Application for Planning Permission

Development: Replacement residential dwelling. This application may affect a Public Right of Way.
Location: 3 The Hard Elmer Middleton-On-Sea PO22 6JS

DWG NO
789/PL002

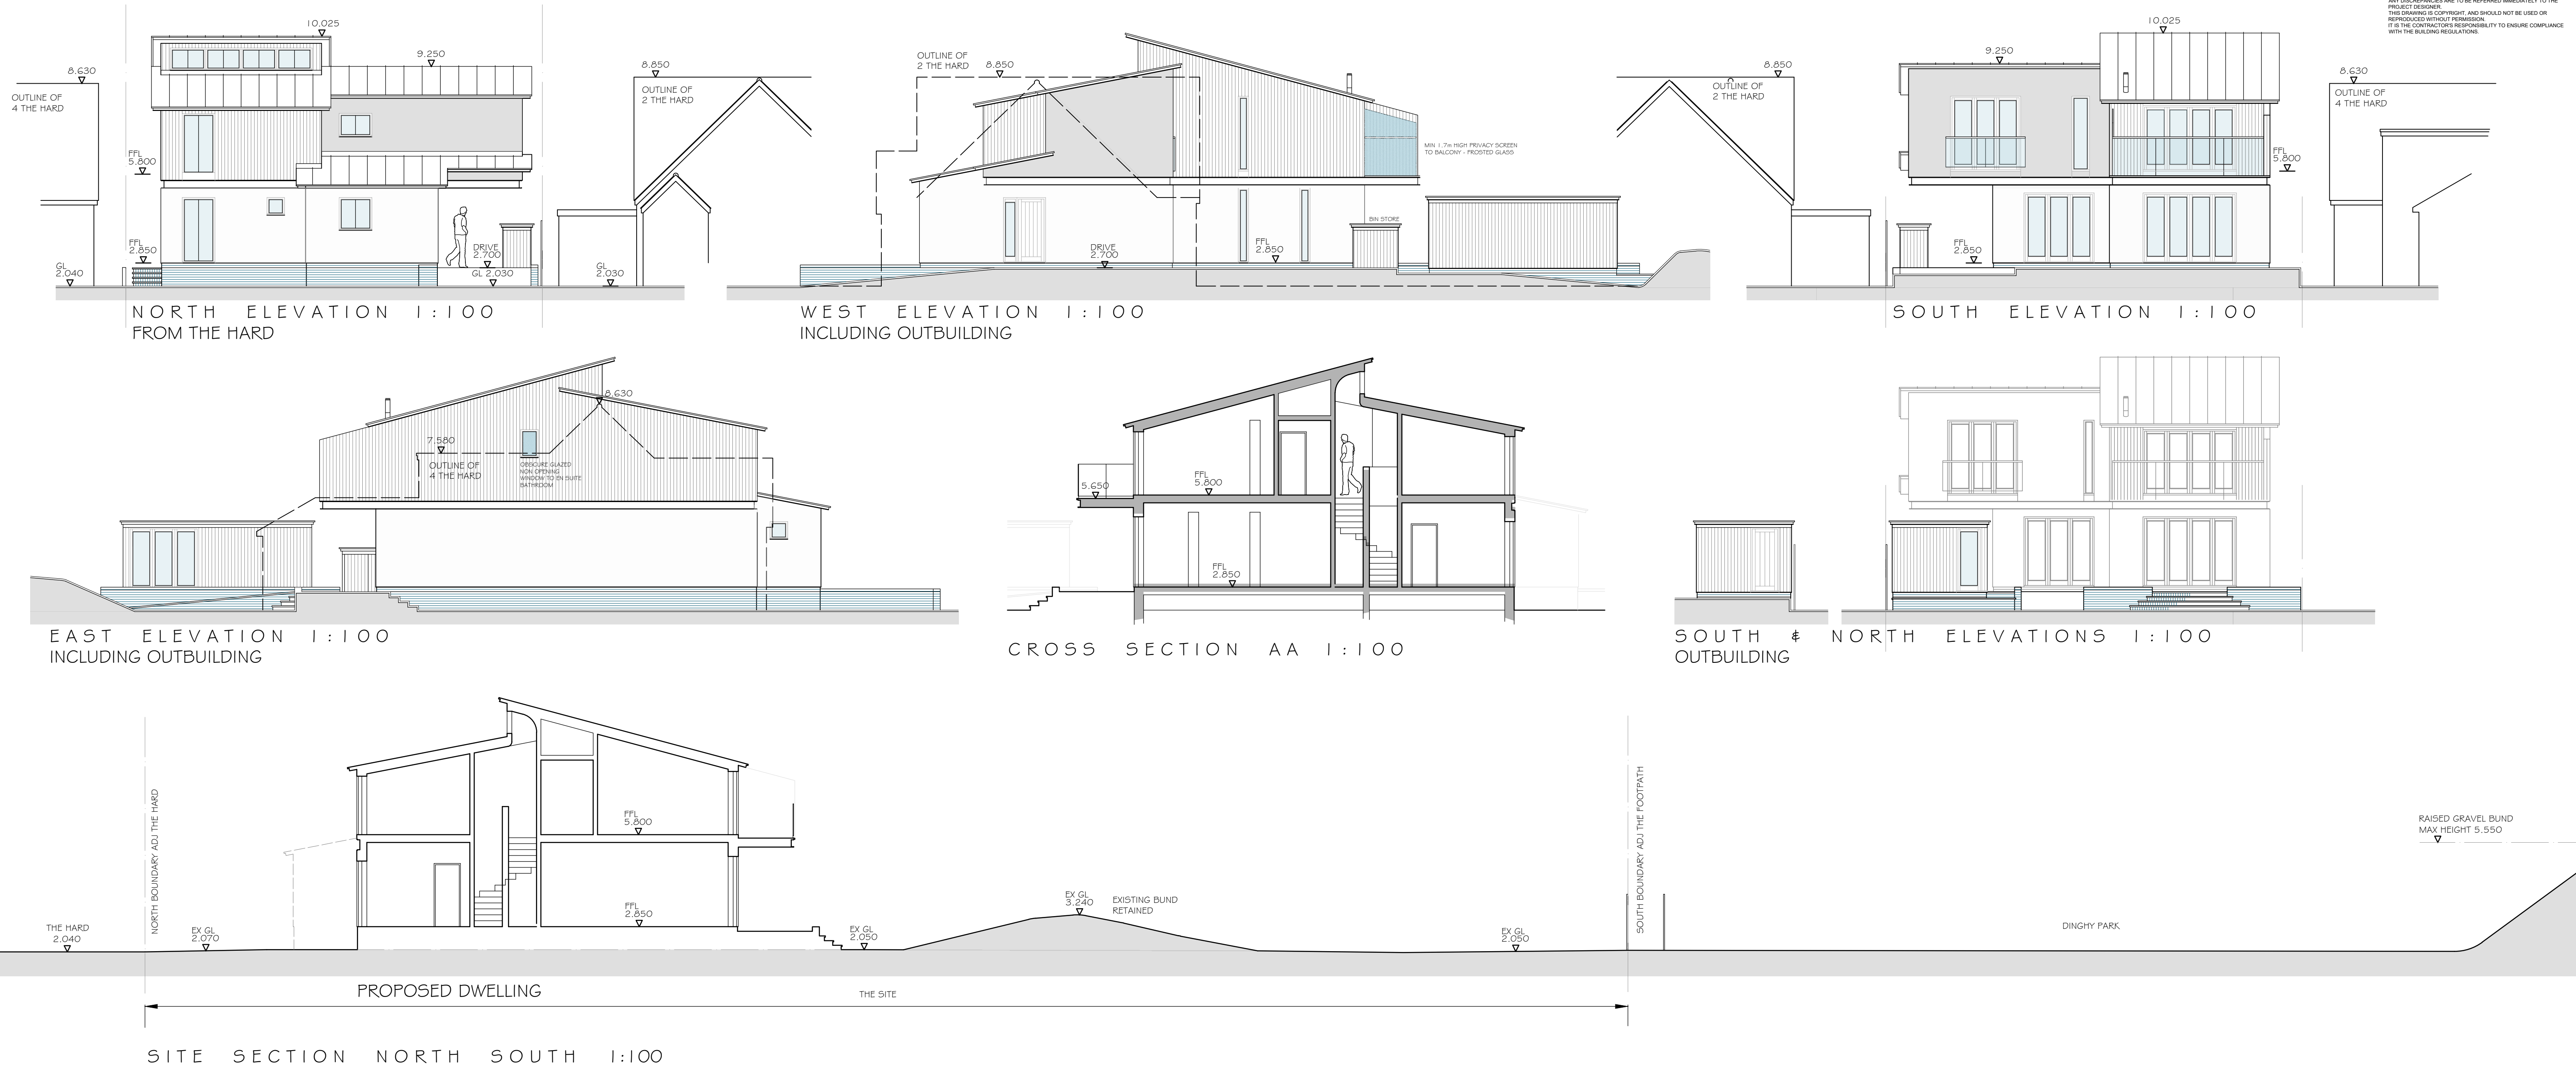
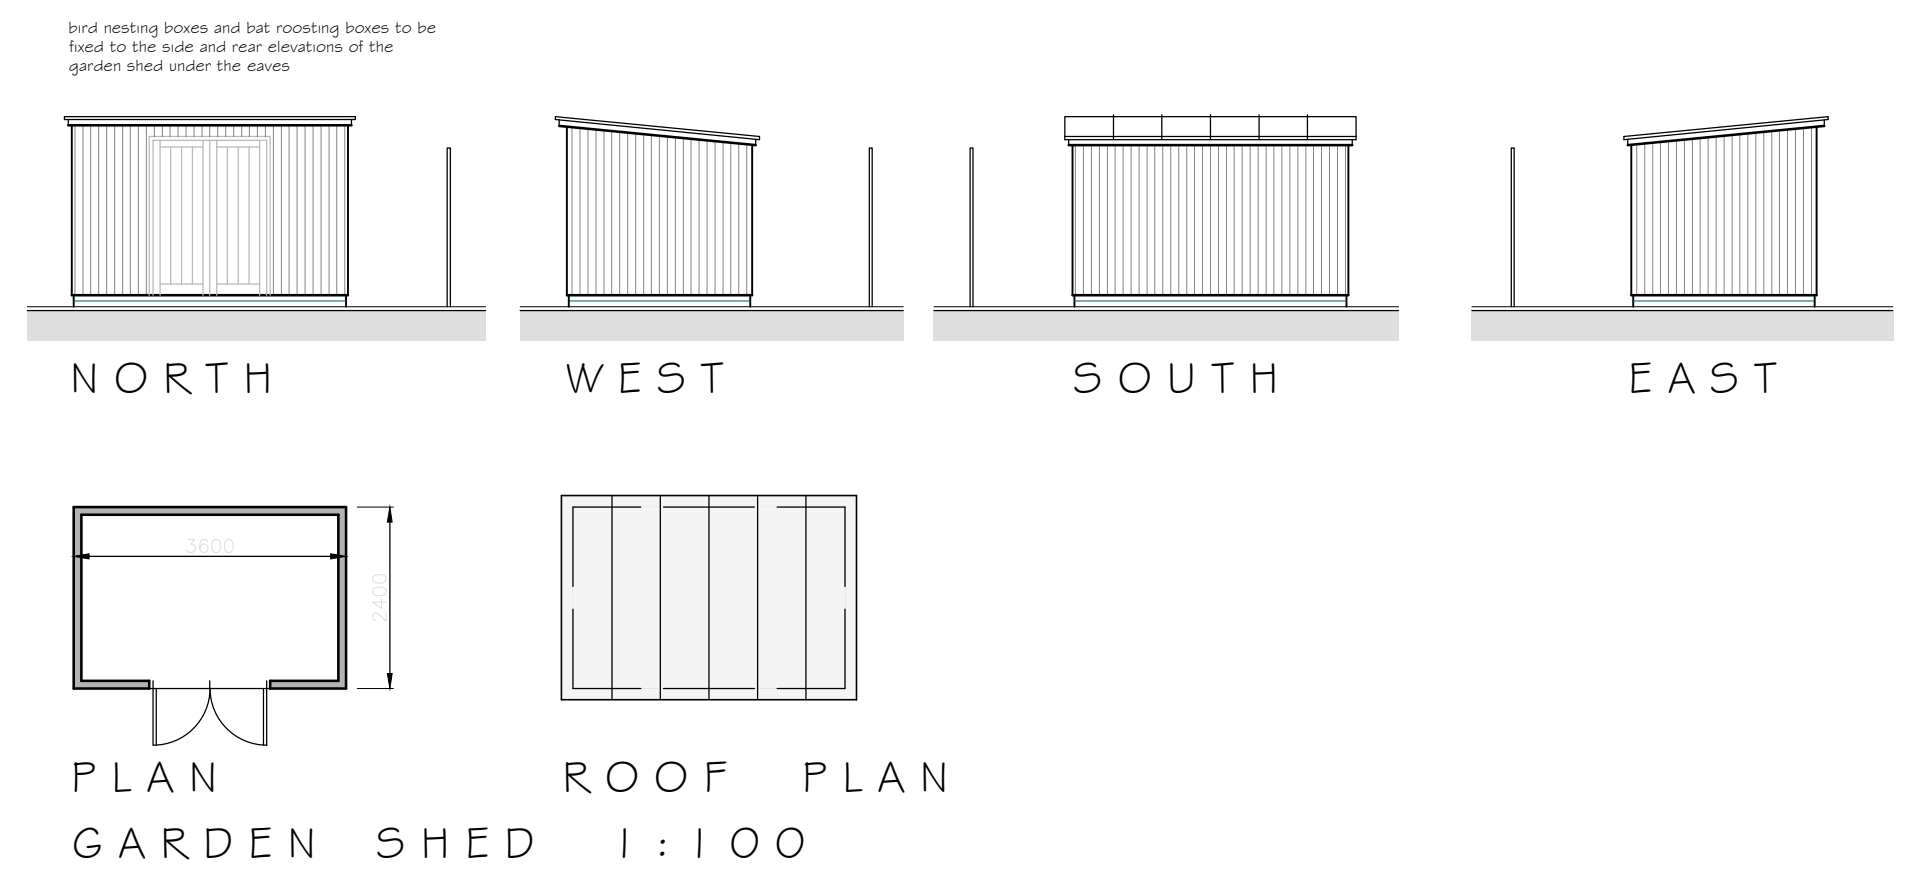
The South elevation 1st floor windows measure: 2.2m, 0.3m and 2.9m, but on the Proposed 1st floor plan measure 2.2m, 0.5m and 2.9m. Please check the measurement of the middle window, amend accordingly and re submit.

The Proposed North elevation appears to include windows on a second floor, but these are not shown on the proposed floor plans. Please clarify, amend accordingly and re submit.
